**Town and Country Planning Act 1990 (As amended)
Town and Country Planning (General Permitted development) Order 2015 Schedule 2 Part 1
Class A
Application for Prior Notification for a householder extension**

Development Notification under extended permitted development rights for replacement conservatory extending 3.30m from the original rear wall of the dwelling house. 3m high with an eaves height of 0m

Location 8 Whitebeam Way Middleton-on-Sea

location plan

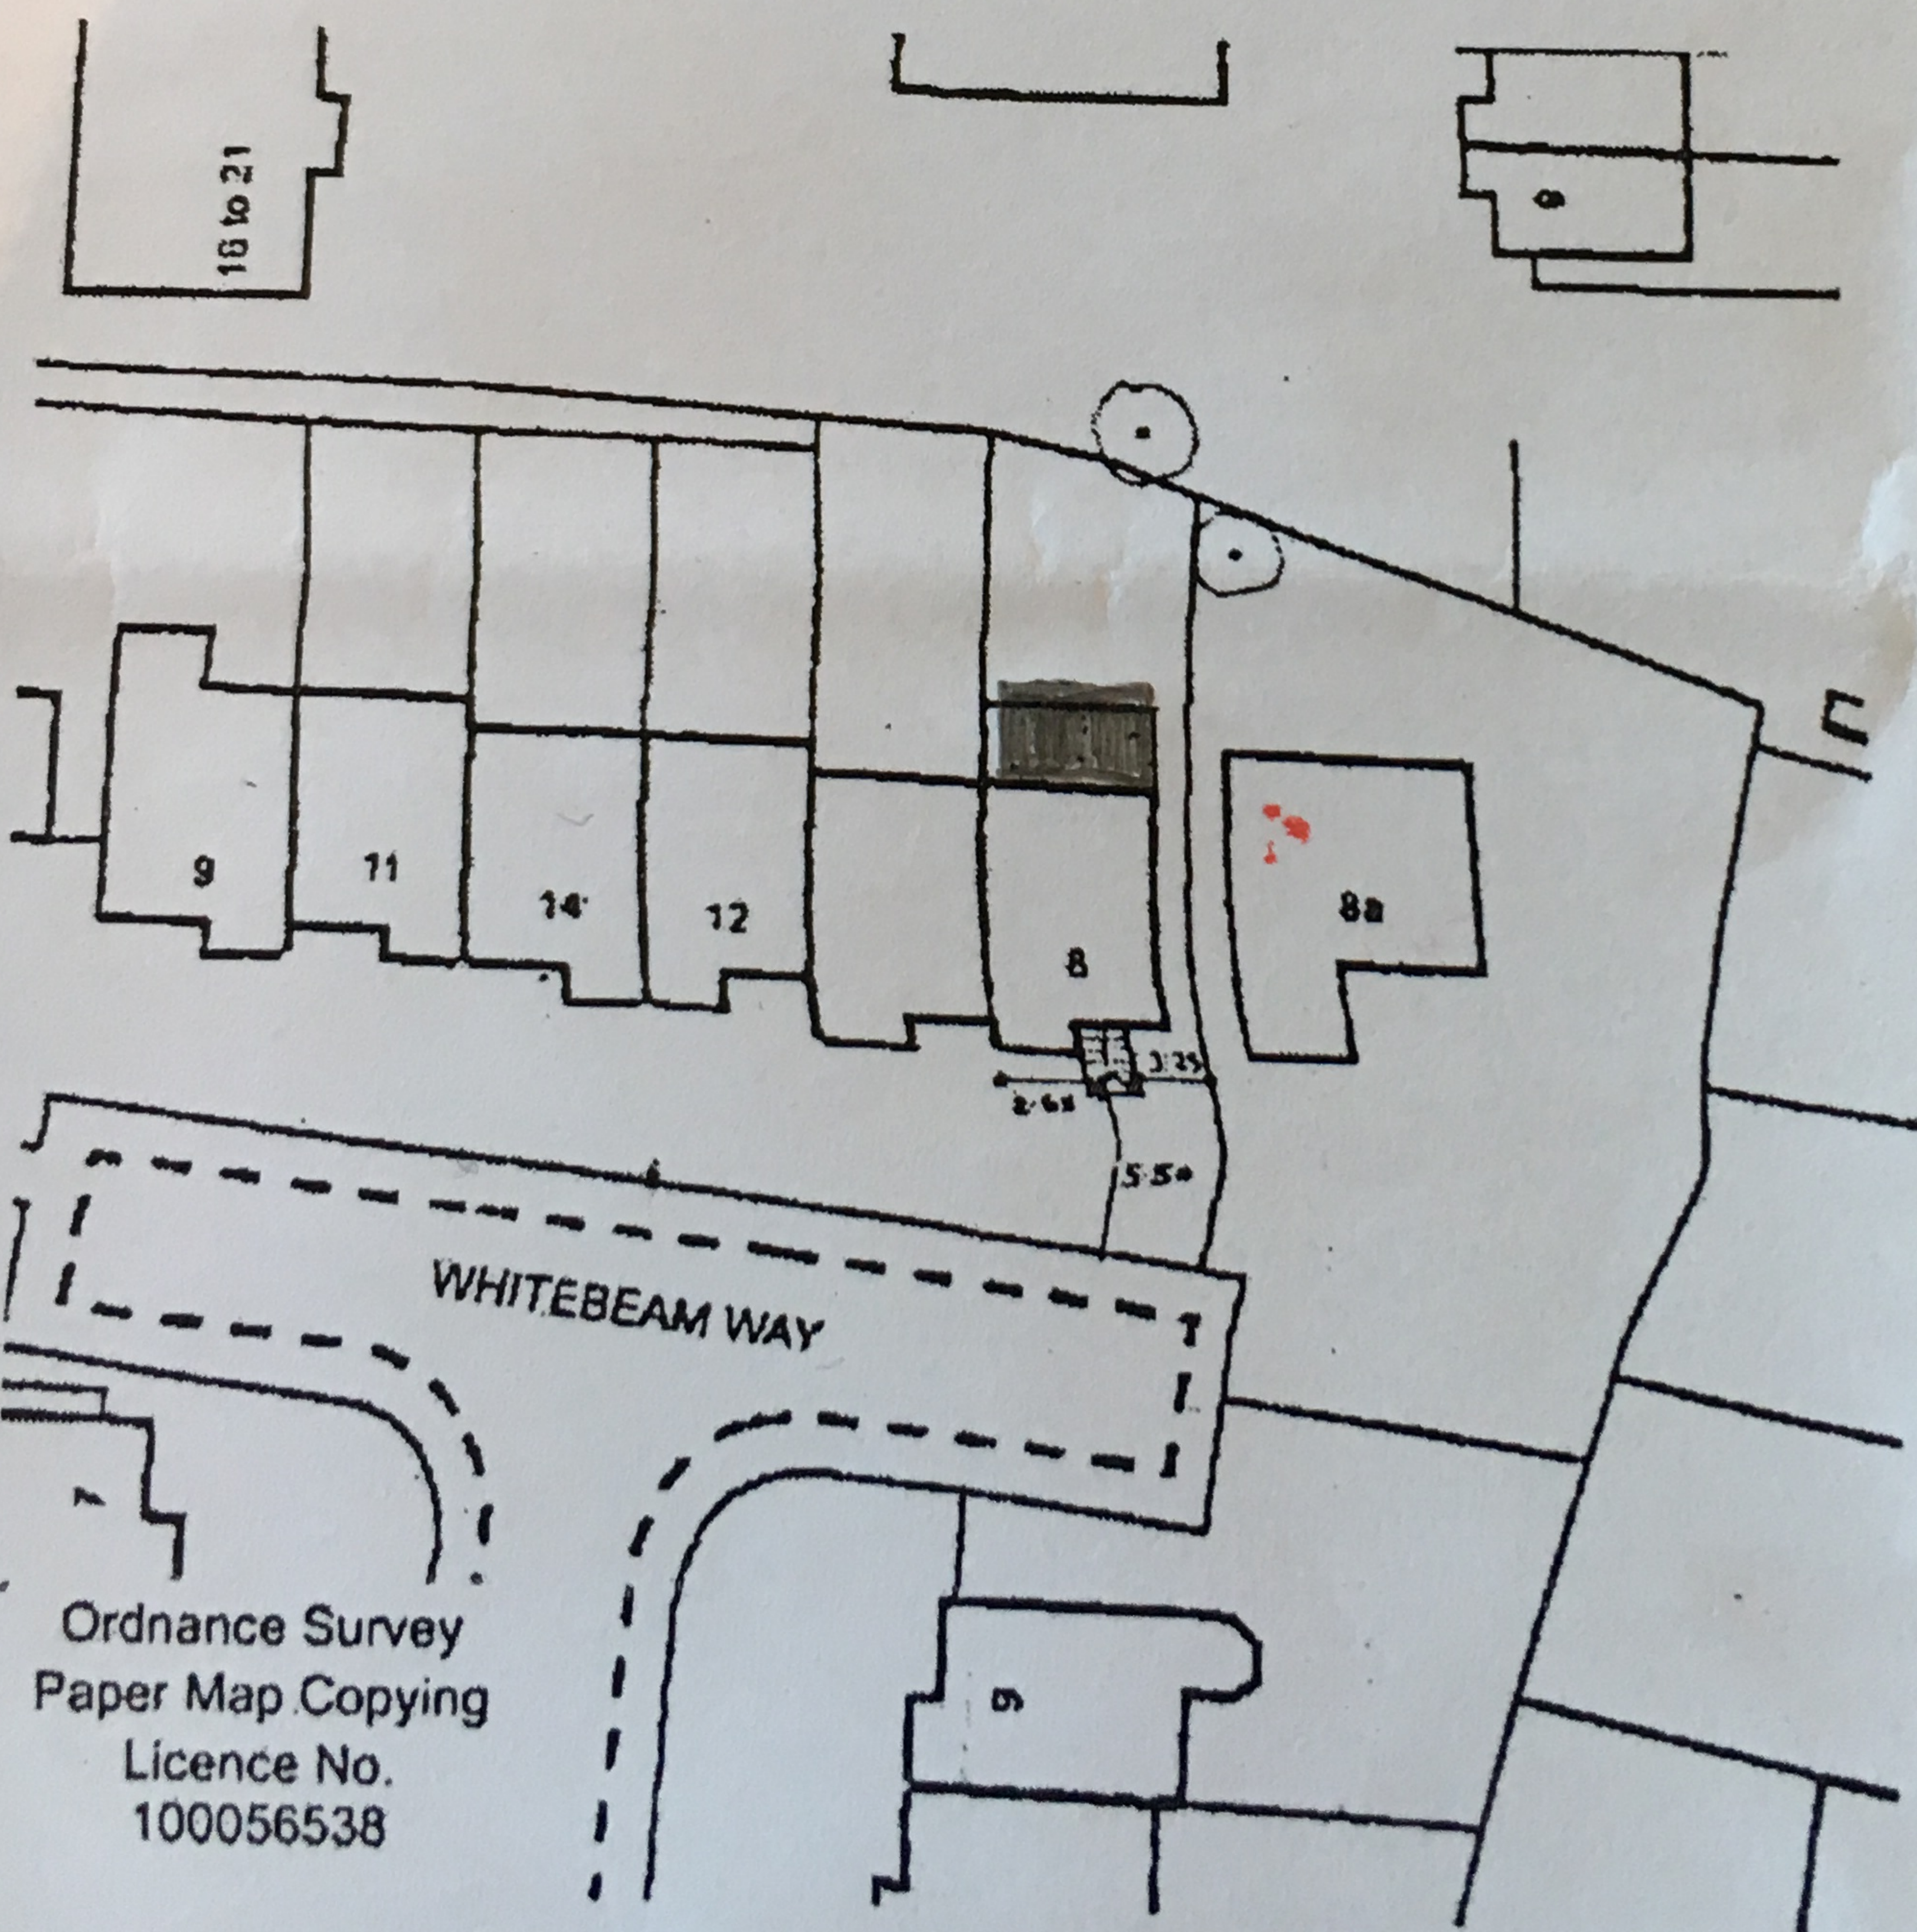
A plan showing the site & surrounding properties is required. This should show the position of the proposal.
